Arun District Council
Arun Civic Centre
Maltravers Road
Littlehampton
West Sussex BN17 5LF
Planning & Building Control General Enquiries
Tel: (01903) 737756 Fax: (01903) 730442
Dx: 57406 Littlehampton
Minicom: 01903 732765
e-mail: planning@arun.gov.uk
website: www.arun.gov.uk/planning

Application No: FP/223/20/T
Site Address: 12 Grafton Avenue Felpham PO22 6AR
Description of works: Reduce 1 No Yew tree (T1) to height 8m and spread 6m.
Fell 1 No. Yew tree (T2).

Photographs of T2 and crack in wall

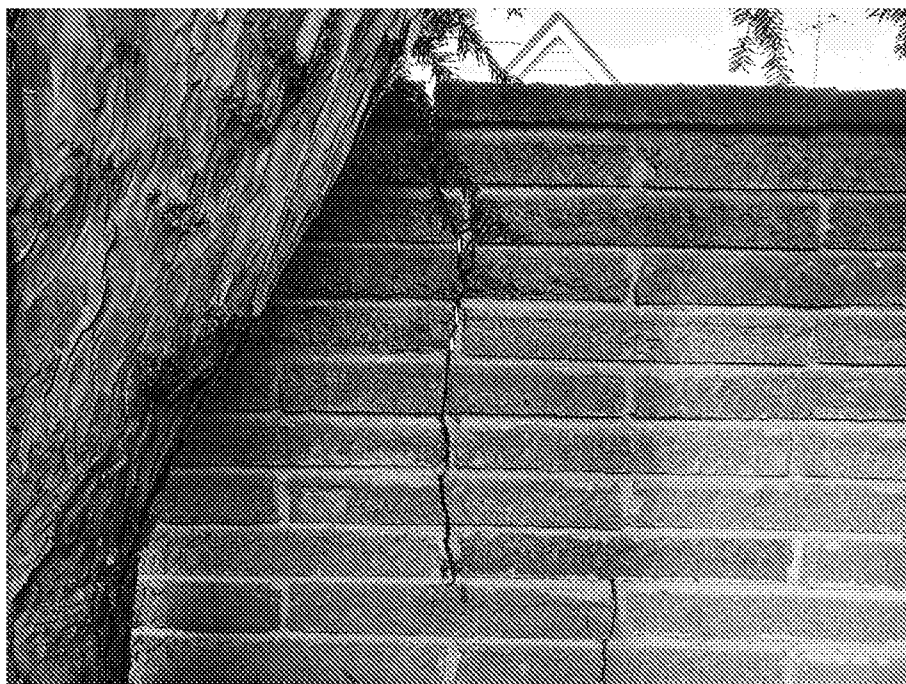
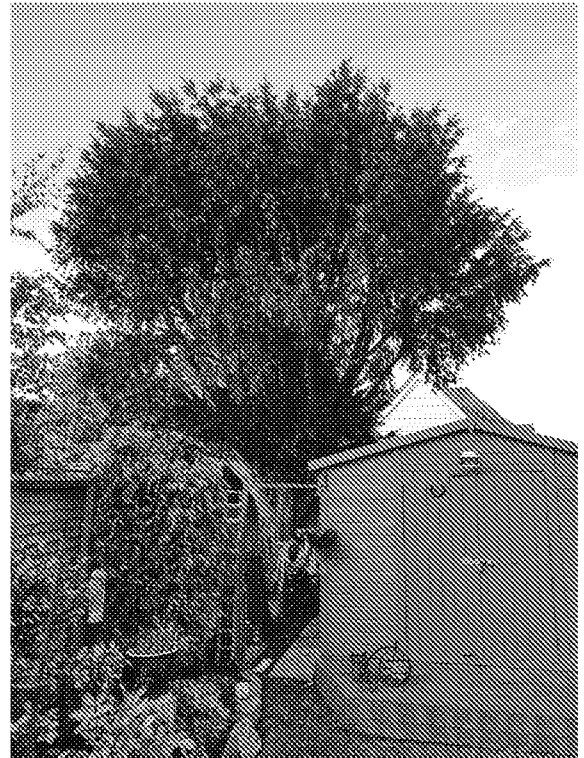
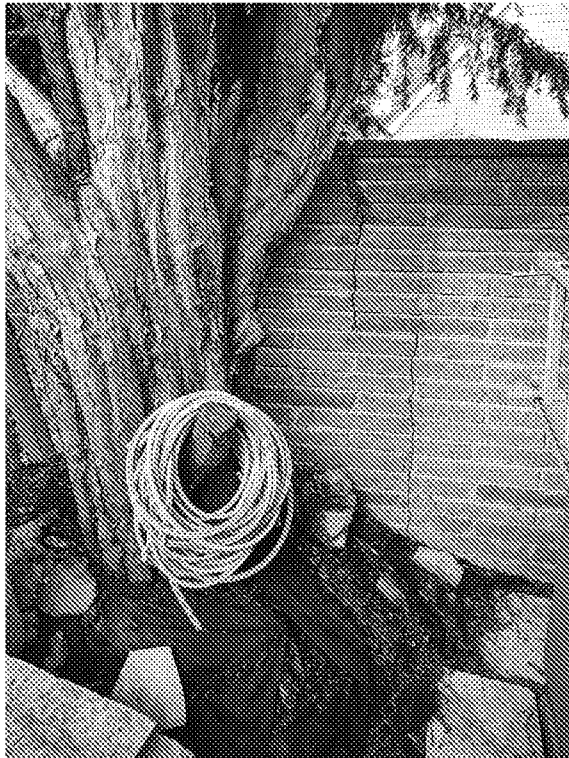
Objection to Felling (T2) Yew tree. Tree Warden advises on (T1) work can go ahead, but on (T2) felling is not required, just trimming using a qualified and professional Tree Surgeon.
